Job ID: 2011-05-1135-FAFS
Installation of a Master box fire alarm

For installation at: 254 COMMERCIAL ST

# Benjamin Wallace - RE: Merrill's Wharf - 254 Commercial St

FIRE ALARM SYSTEM MERRILL WHARF PORTLAND, MAINE

FIRE ALARM
 RISER DIAGRAMS
E3.2
 09.23.2010

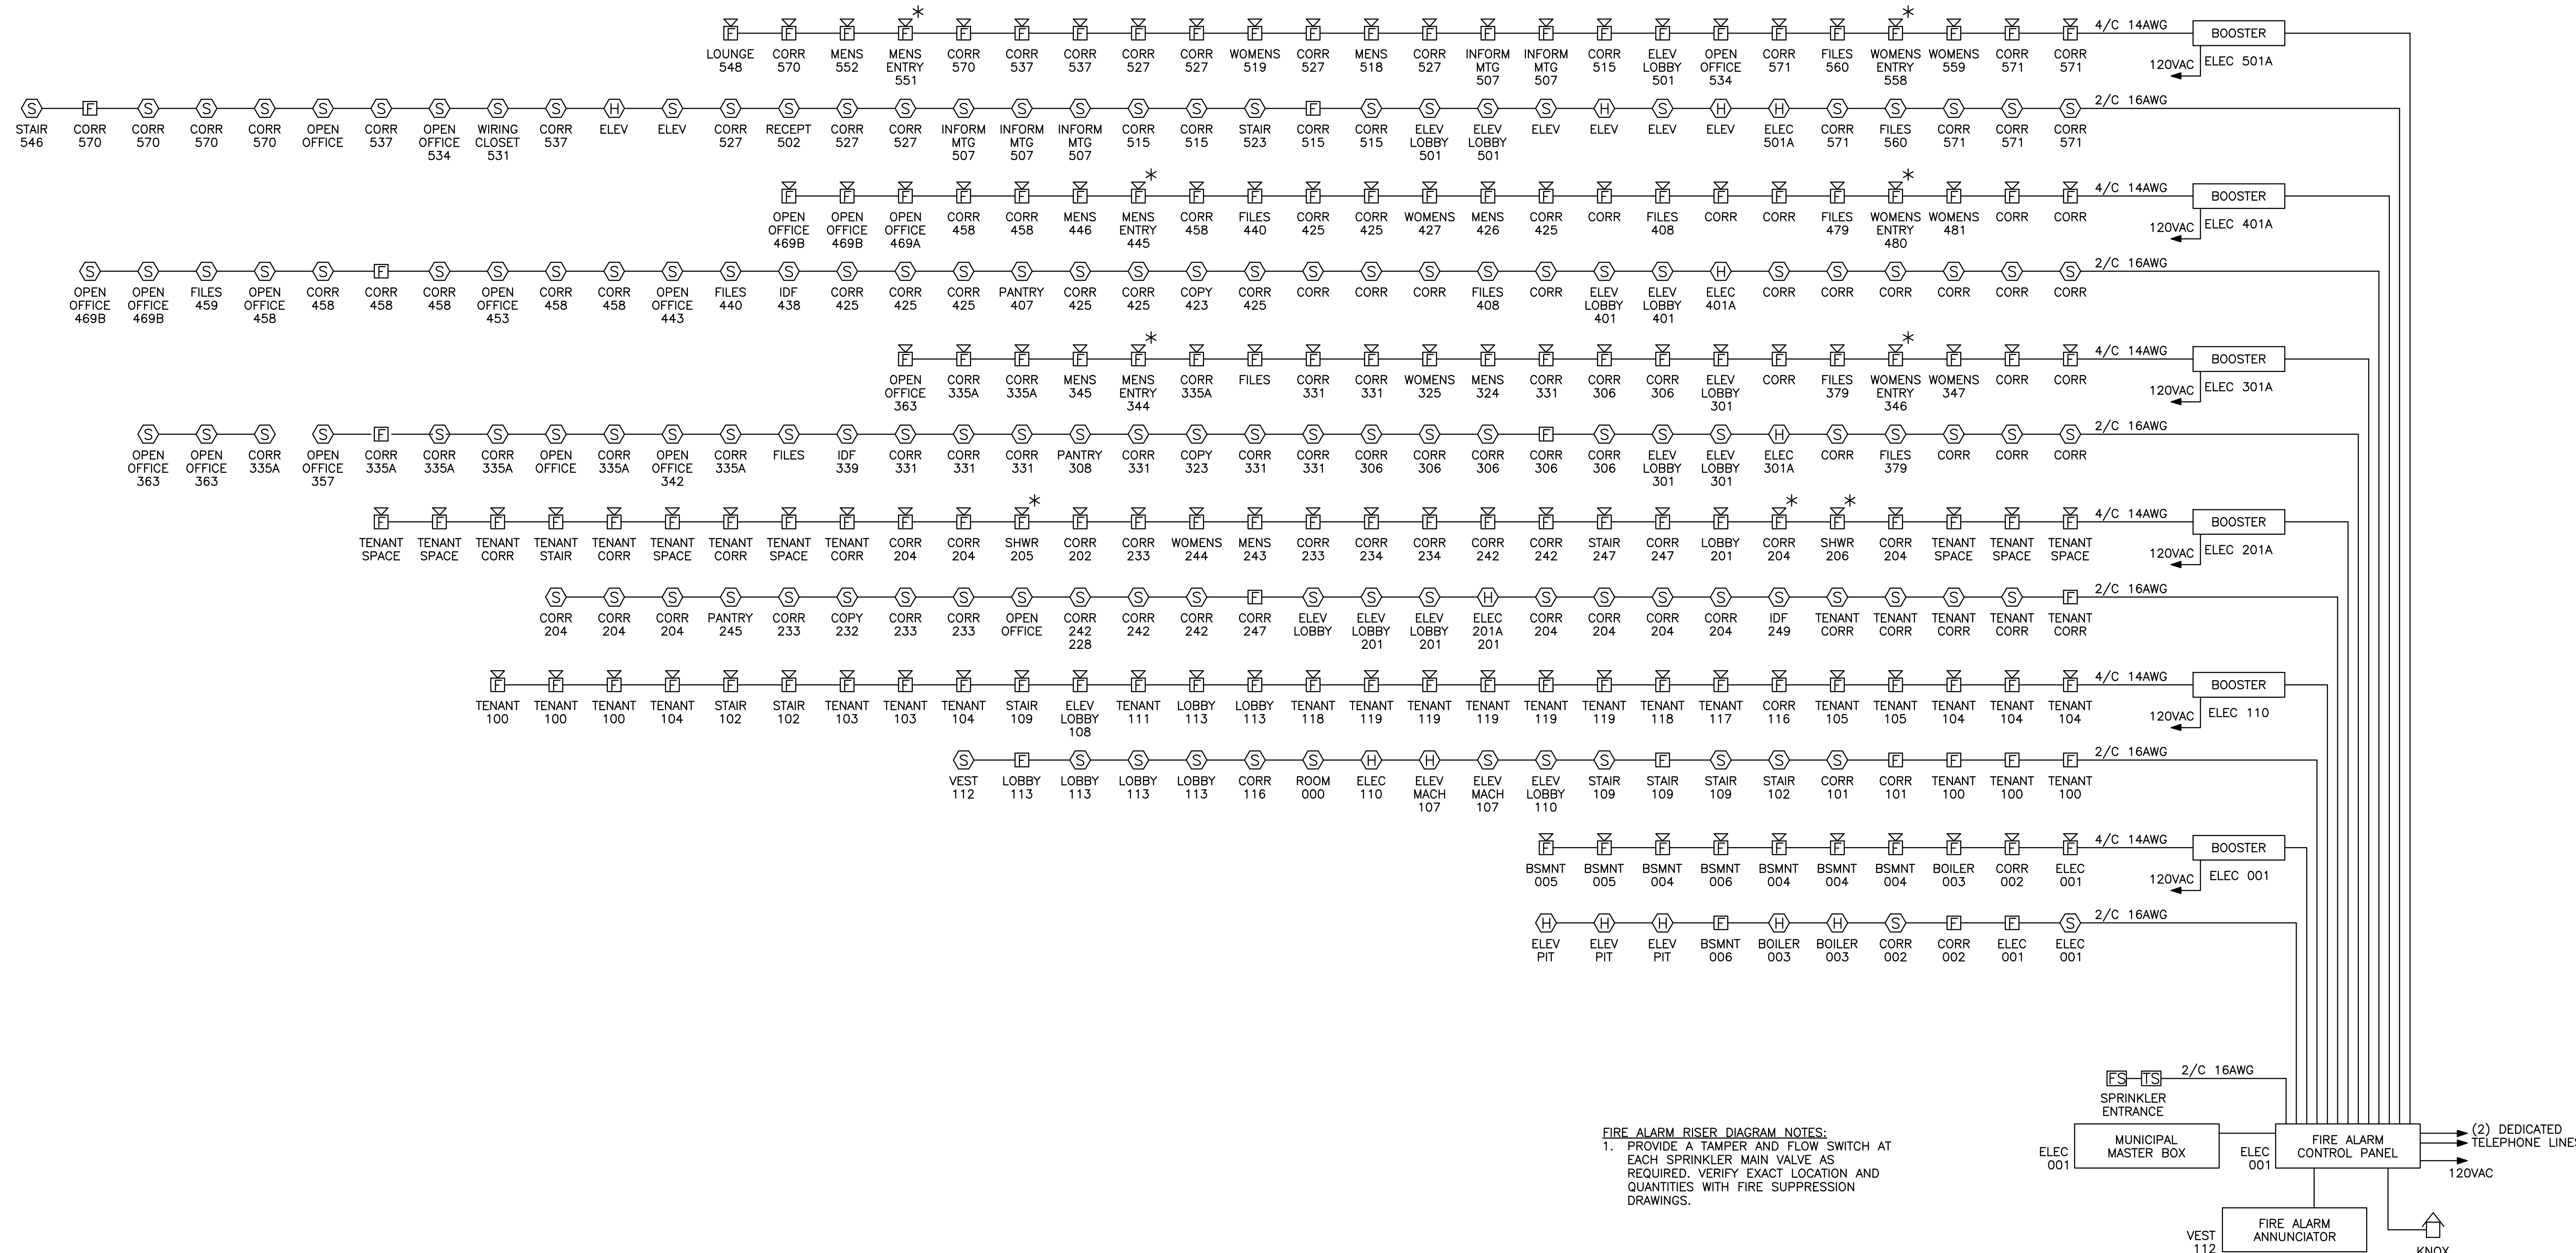
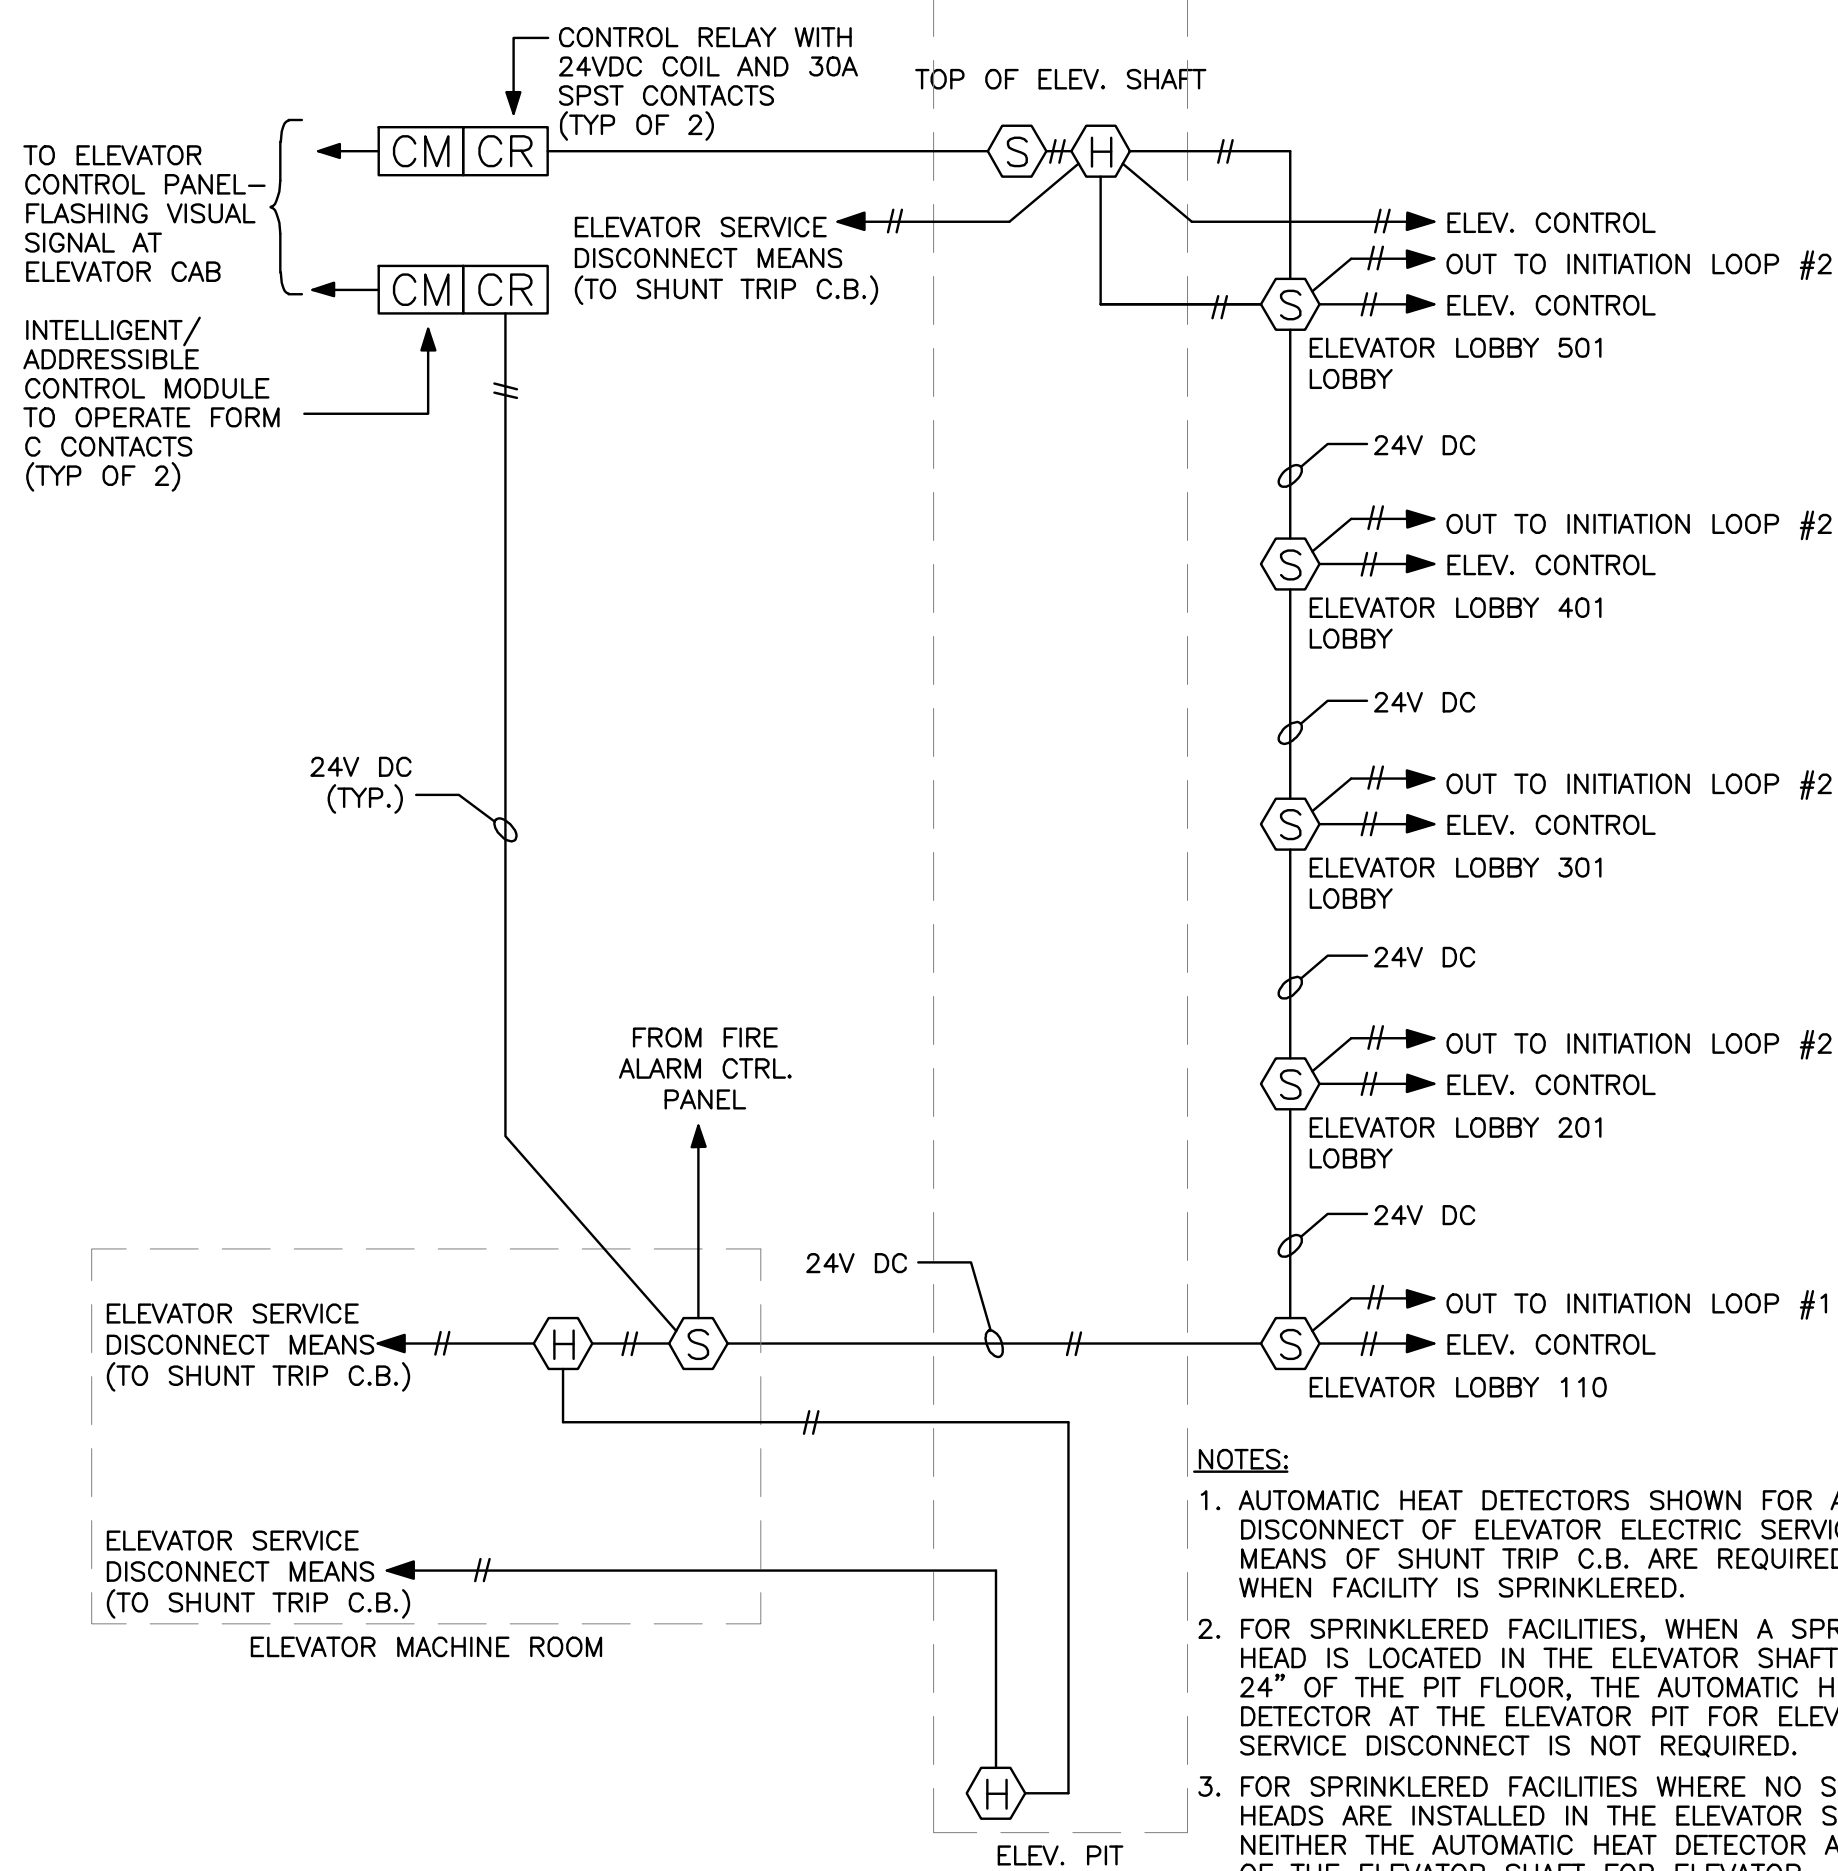
Duct detection shall be supervisory and not trip the evacuation signals or master box.

- 1. Complete smoke detection is not required for this building by the life safety and fire codes. Duct detection (supervisories), elevator detection and the detection for the fire alarm system itself is. Also the plans call for 2 smokes in front of every elevator lobby but as long as there is one within 21' of the centerline of the elevator door its all set. All of the extra detectors are allowed but not required.
- 2. The pull stations and sprinkler water flow and supervision by floor are required.
- 3. The plan doesn't show a pull station from the basement corridor 002 to the exit stair.
- 4. I need the master box approval form for the system.
